**200 Aldington Road Industrial Estate (SSD-10479)
Request for additional information**

I refer to the supplementary Response to Submissions (RTS) report submitted for the 200 Aldington Road Industrial Estate (SSD-10479).

Attachment 1

Project	PROPOSED INDUSTRIAL DEVELOPMENT 200 ALDINGTON	
Title	BULK EARTHWORKS GENERAL ARRANGEMENT PLAN	
Drawing No.	Project No.	Issue
19-609-C1030	19-609	A

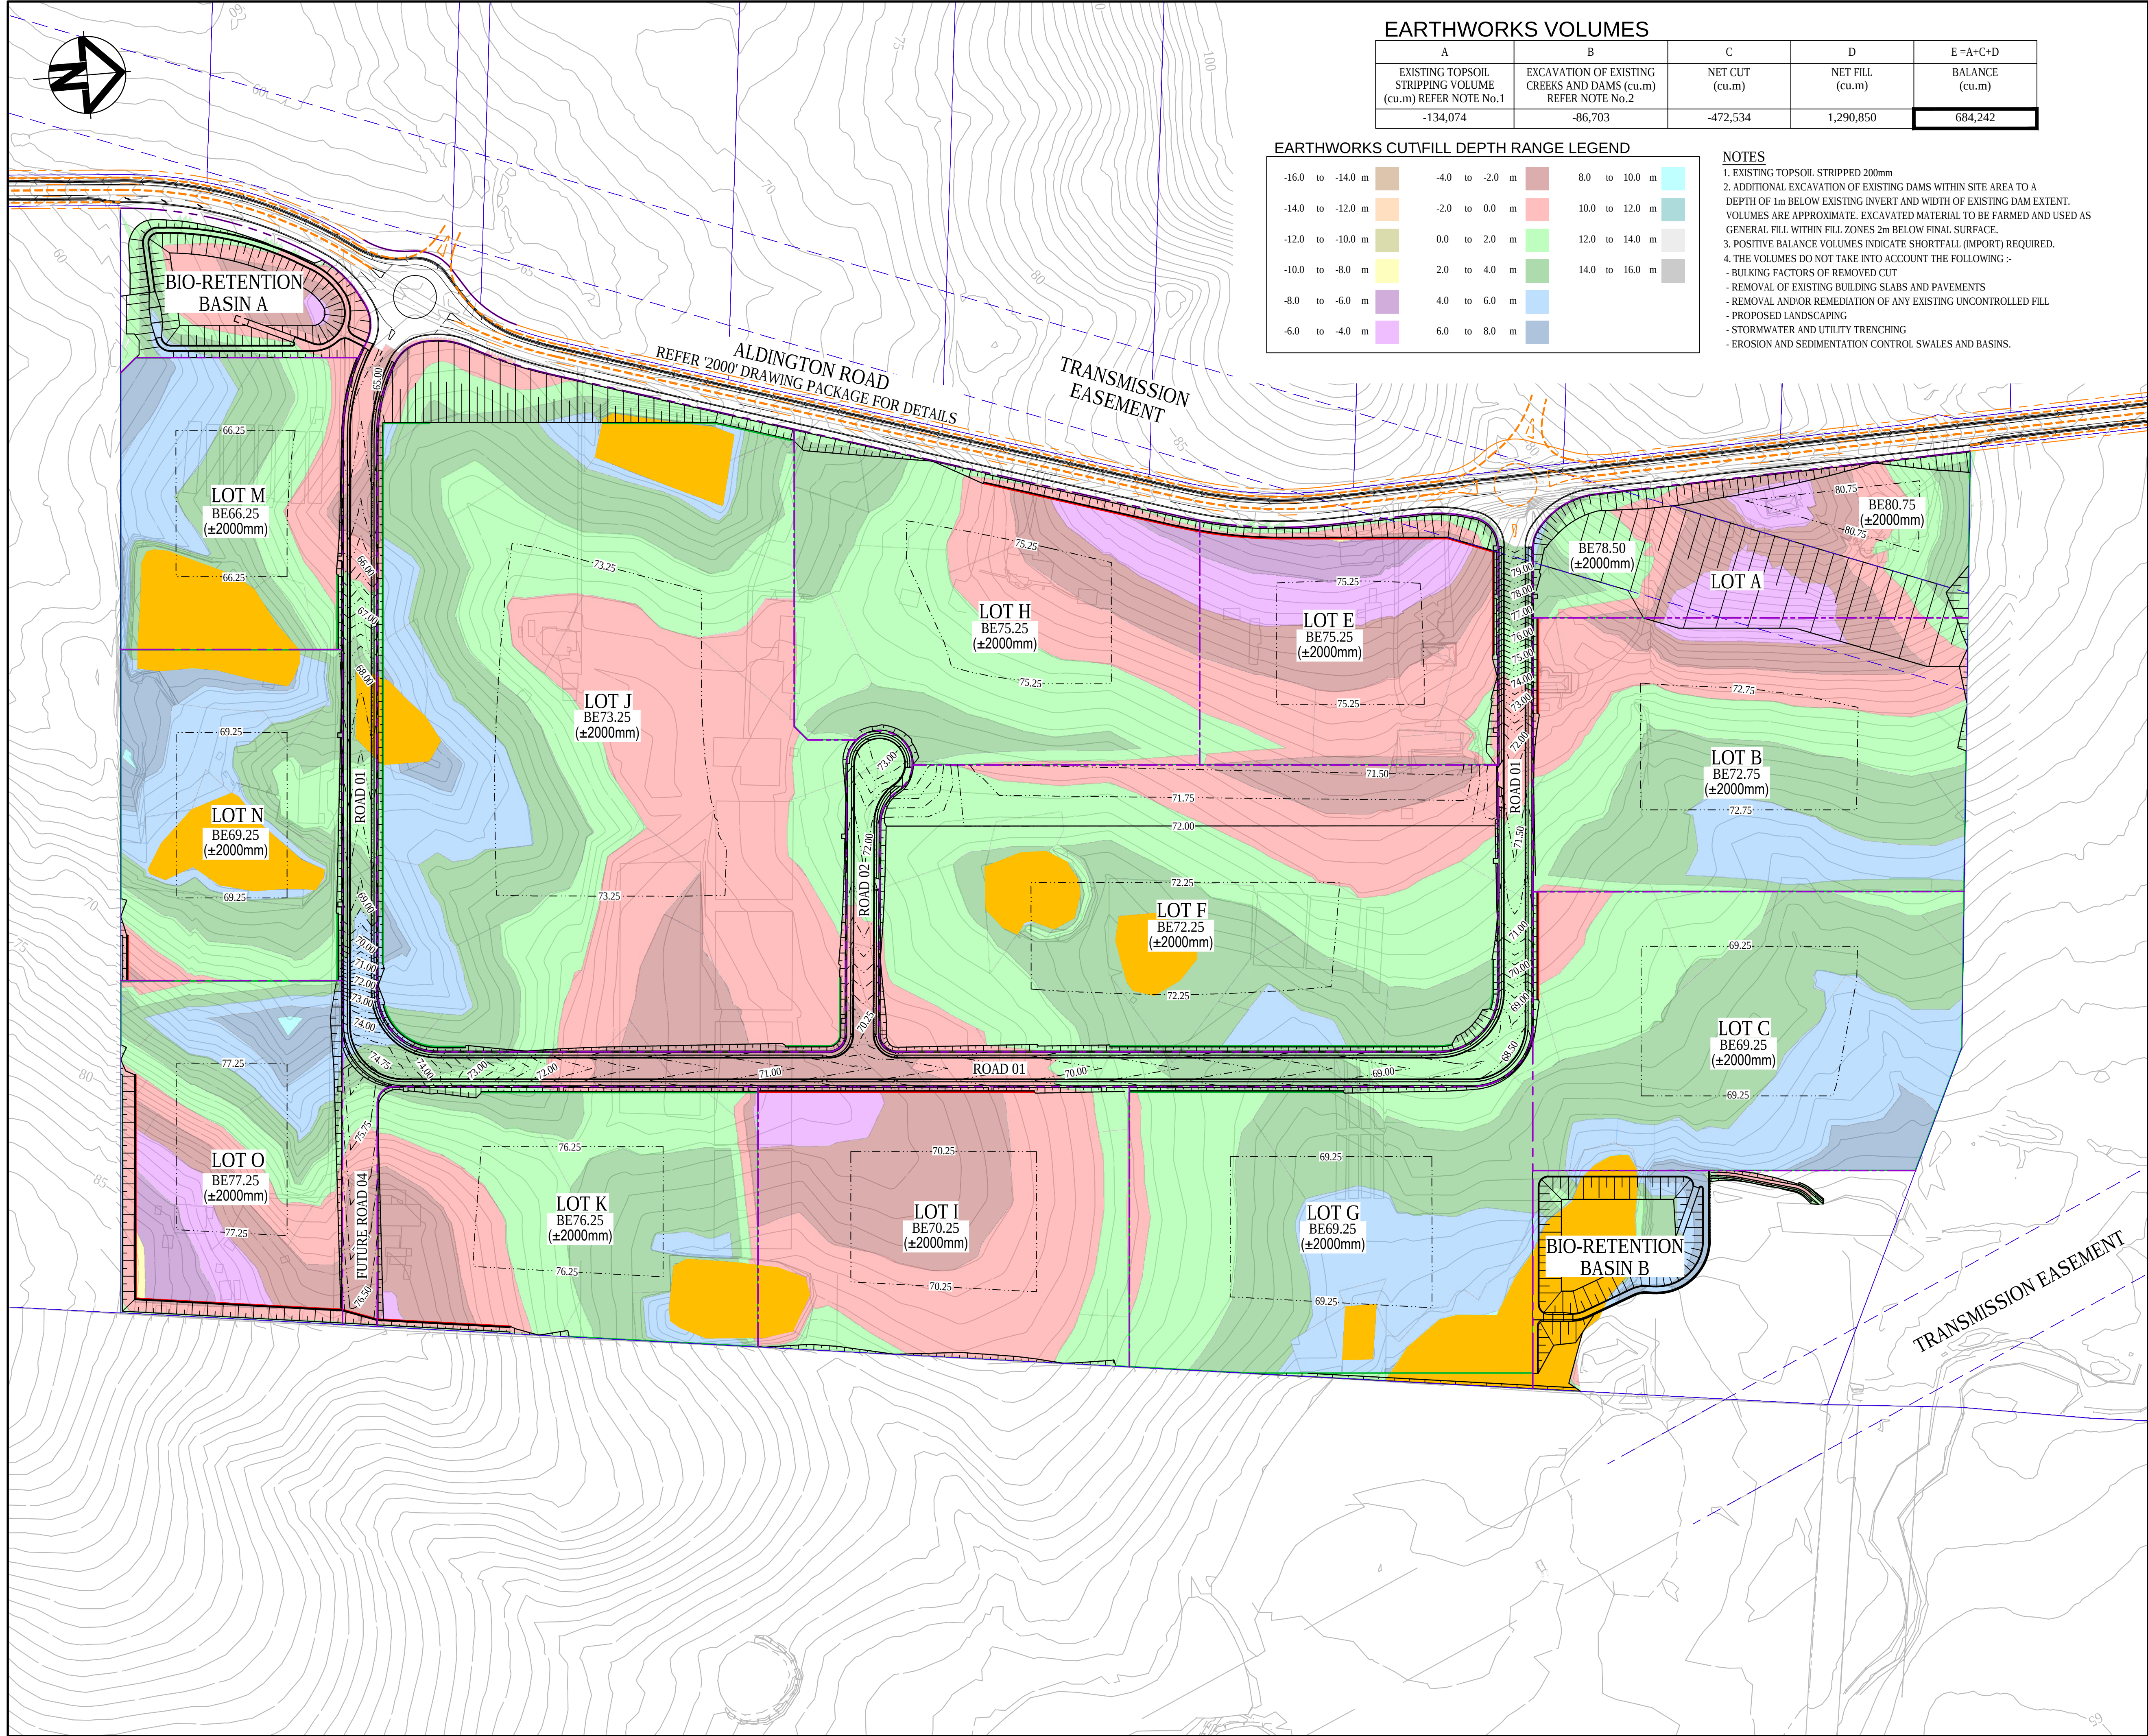
- The development proposes significant earthworks across the site and does not achieve balanced cut and fill. It must be ensured that earthworks meet the requirements of clause 33H of the WSEA SEPP. The development should seek to deliver balanced cut and fill and minimise retaining walls where possible. Retaining walls addressing the public domain must be stepped and have a maximum height of 6 m. The Department also notes the concerns raised by Council with regard to the design of retaining walls within the site and requests a response is provided to the matters.

Title
**RETAINING WALL
GENERAL ARRANGEMENT
PLAN**

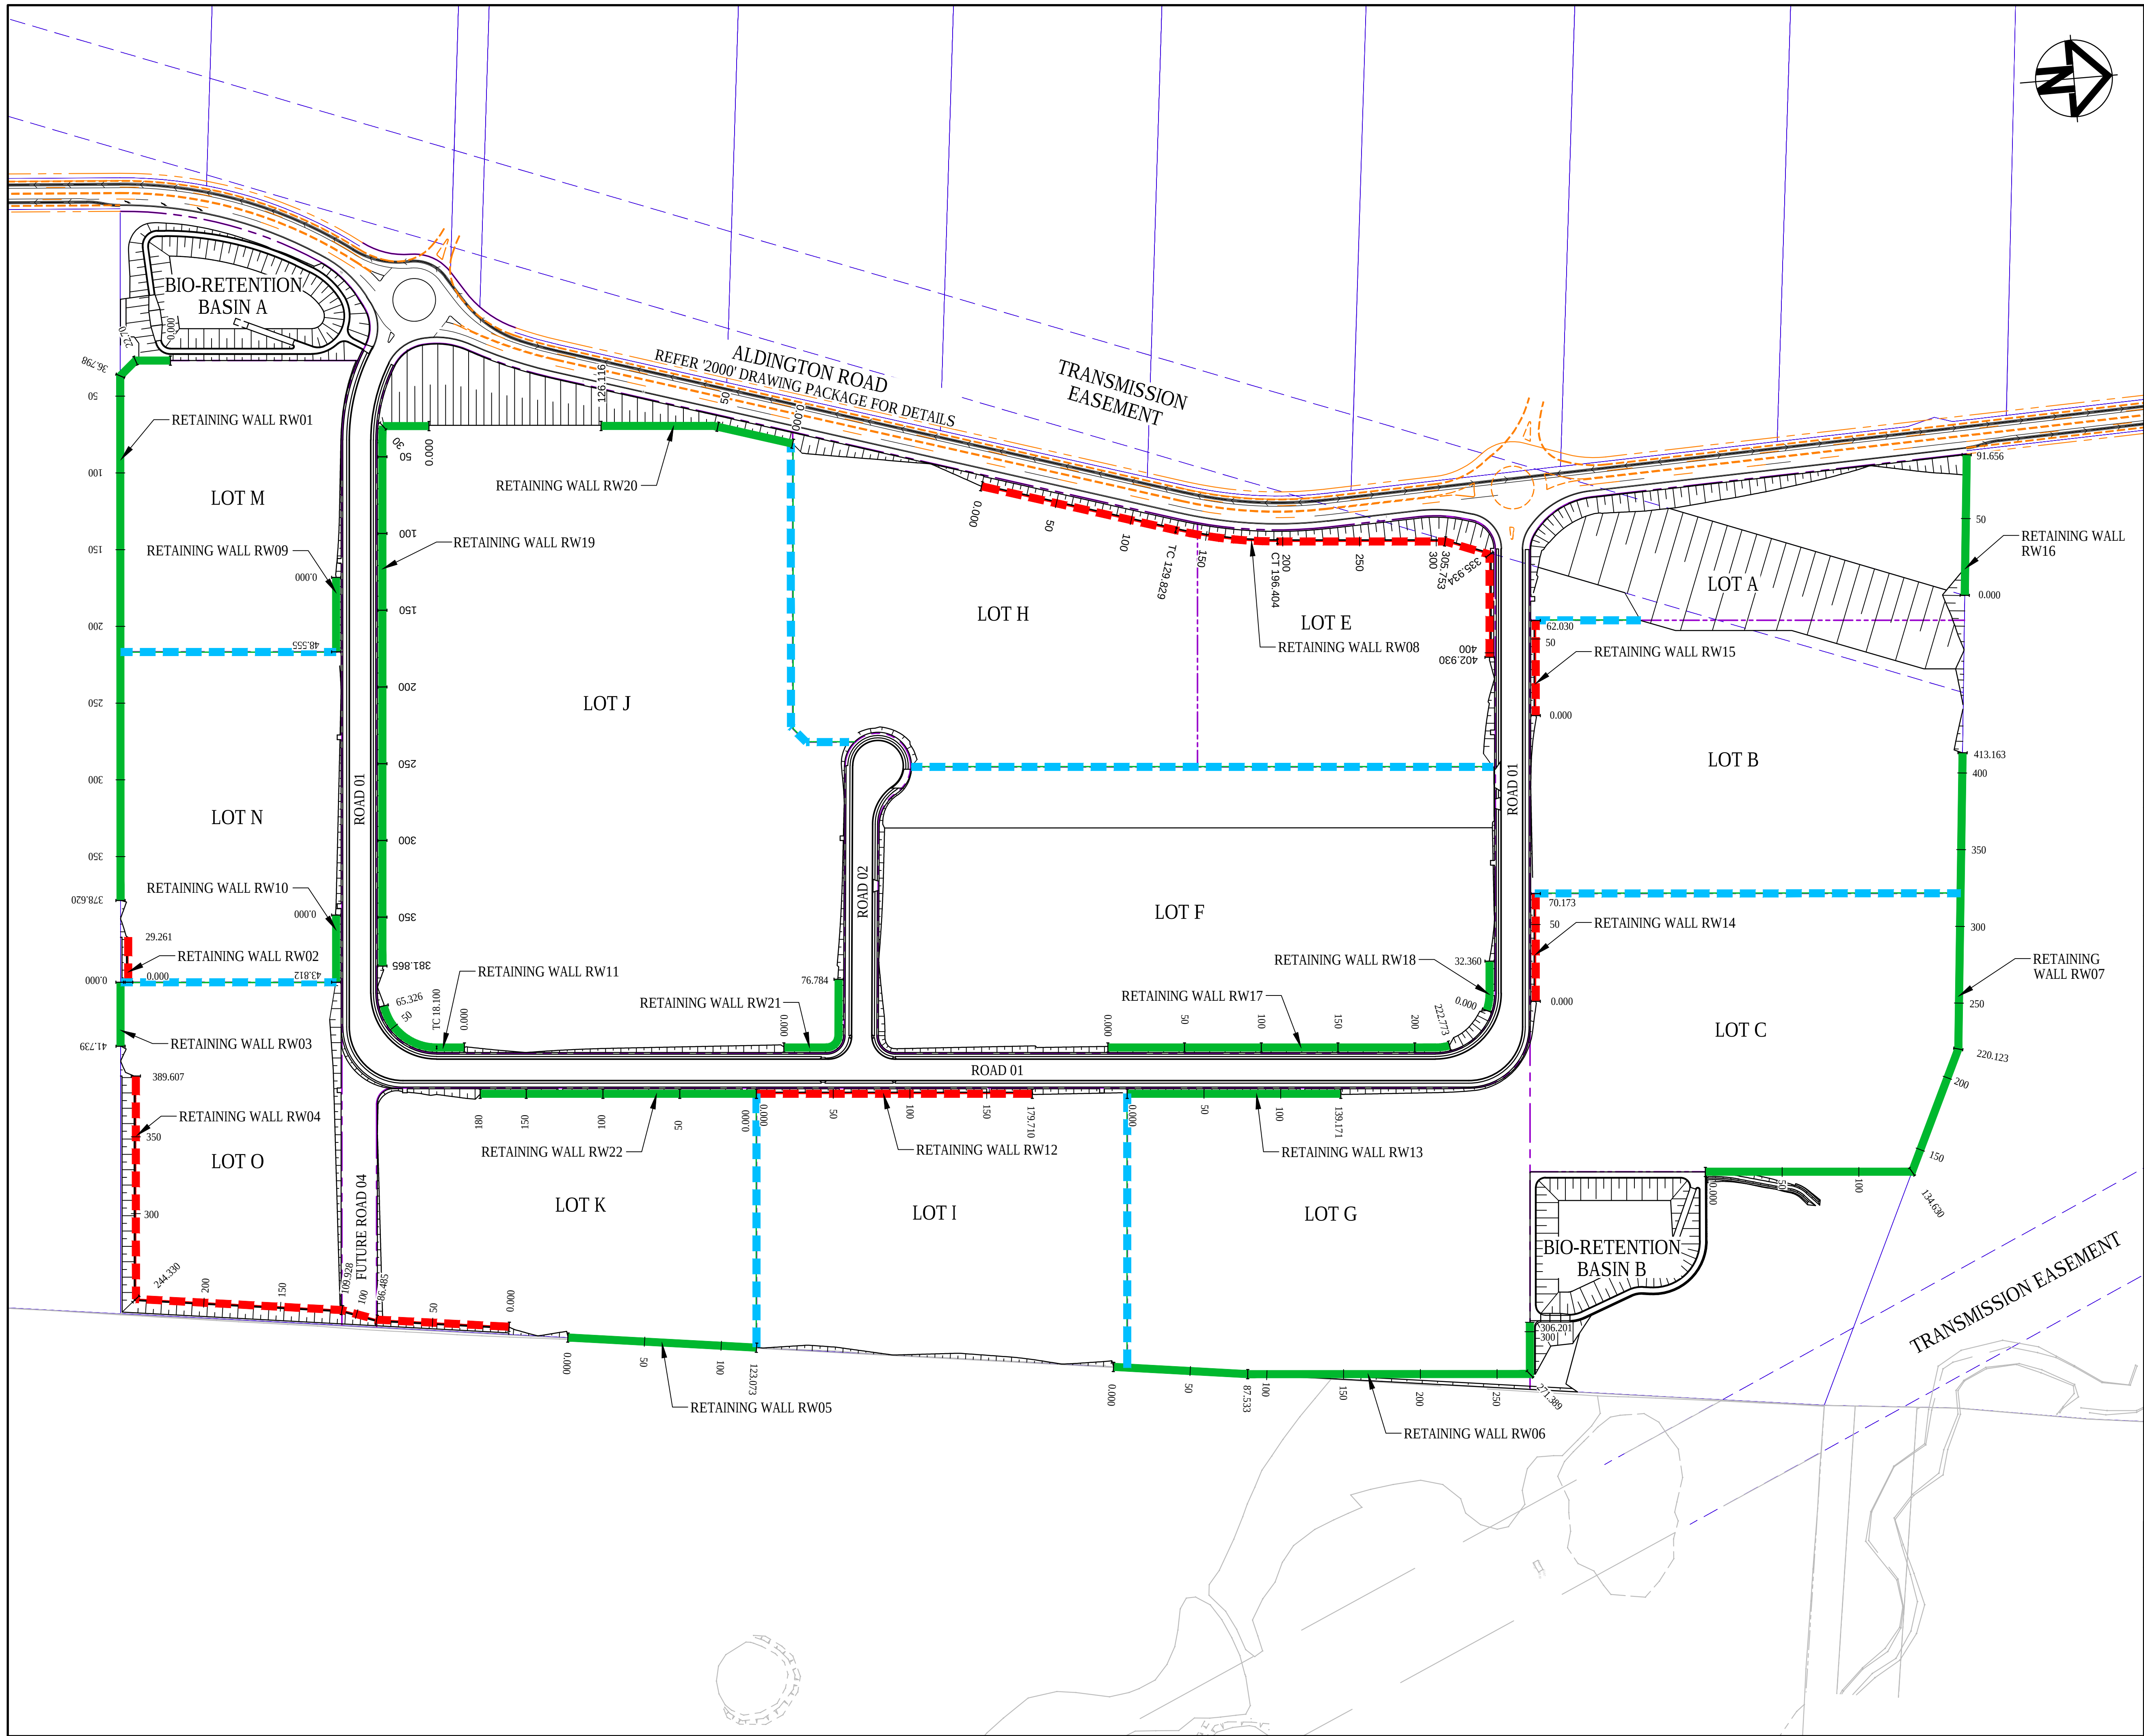
- The Department continues to have concerns with the proposed fill retaining walls along the southern boundary of the site, including the height, design and adequacy of landscaping treatment to reduce visual and bulk impacts to the adjoining property. The draft MRP DCP requires retaining walls over 3.0m high be tiered.

- Please clarify the likely heights of any retaining walls required along the northern boundary of Lots A, B and C once the northern boundary road is constructed and confirm that the required setbacks and landscaping can be achieved.

- The Department notes the inclusion of the 'open space edge road' in the Concept and Stage 1 plans and proposed retaining walls between the road and RE2 zoned land. Consideration is to be given to the provisions of Section 4.4.1 and Control 23 in Section 3.4.1 of the draft MRP DCP with regard to levels and design of retaining walls adjoining the public domain.
